WEST SUSSEX COUNTY COUNCIL CONSULTATION

TO:	Arun District Council - FAO: Hannah Kersley
FROM:	WSCC – Highways Authority
DATE:	20 August 2025
LOCATION:	Westholme Nursery Toddington Lane Littlehampton BN17 7PP
SUBJECT:	LU/83/25/OUT Outline planning application (with all matters except access reserved) for the construction of 31 No. residential units. This application is in CIL zone 2 (CIL liable) and may affect the setting of listed buildings. Substitute Transport Documents received.
RECOMMENDATION:	No Objection

ACCESS DIMENSIONS 1:200

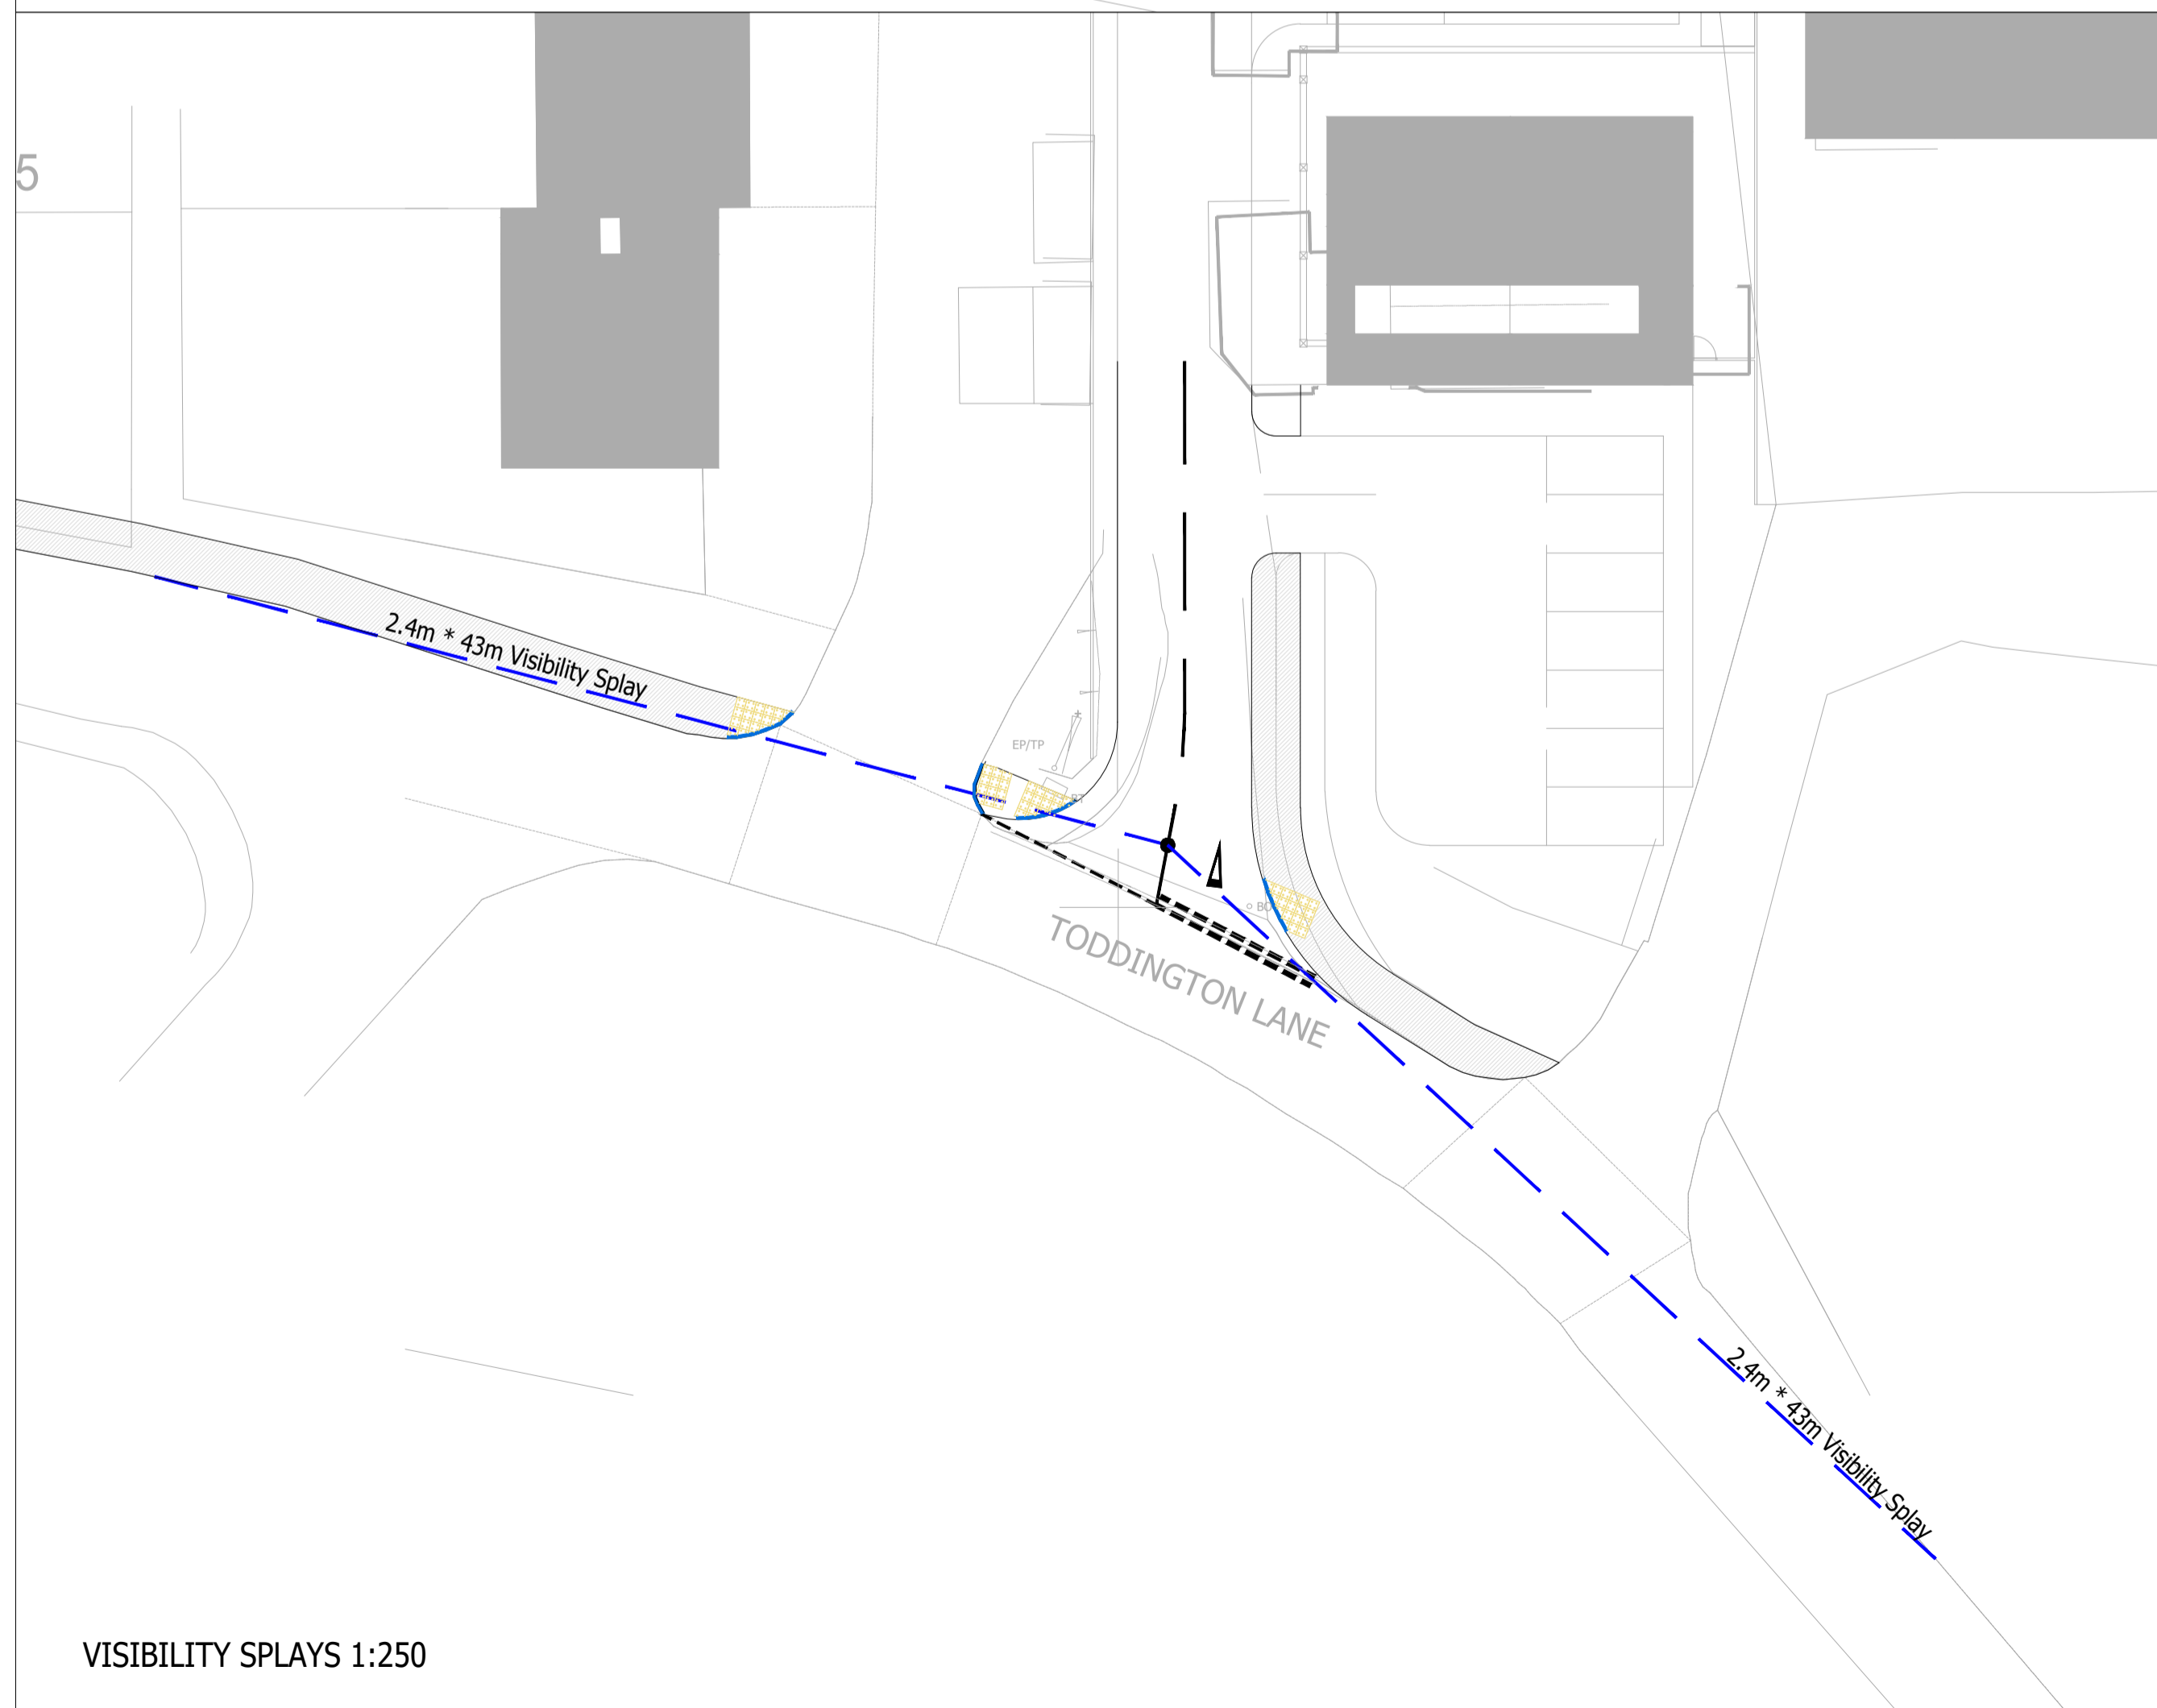
West Sussex County Council, in its capacity as Local Highway Authority (LHA), have been re-consulted on outline proposals for 31 x dwellings. In comments dated 23 June 2025 the LHA requested further information in respect to footway connection in to the site from Toddington Lane, crossing of Toddington Lane and uncontrolled crossing of site access along with Designers Response.

Updated plans have been provided showing linking footway along Toddington Lane, including dropped kerb and tactile paved crossing of site access, of adjacent access road (Dutch Cottages) and of Toddington Lane (in vicinity of Trevett Place) to link to southern side of carriageway. Designers Response to the Stage 1 Road Safety Audit has also been provided, outlining these improvements in response to 3.1.1. of RSA (lack of footway continuity). The LHA, as Overseeing Organisation, have completed the Designers Response which is included with this response. It is considered the improvements demonstrated on 'PROPOSED SITE ACCESS AND REFUSE VEHICLE SWEPT PATHS (10897_100 P4)' are at a suitable level to link the development to the nearby pedestrian infrastructure, promoting safe and suitable access for all.

No part of the development shall be first occupied until such time as the vehicular access, linking footway and dropped kerb/tactile paved crossing points serving the development has been constructed in accordance with the details shown on the drawing titled PROPOSED SITE ACCESS AND REFUSE VEHICLE SWEPT PATHS and numbered 10897_100 P4.
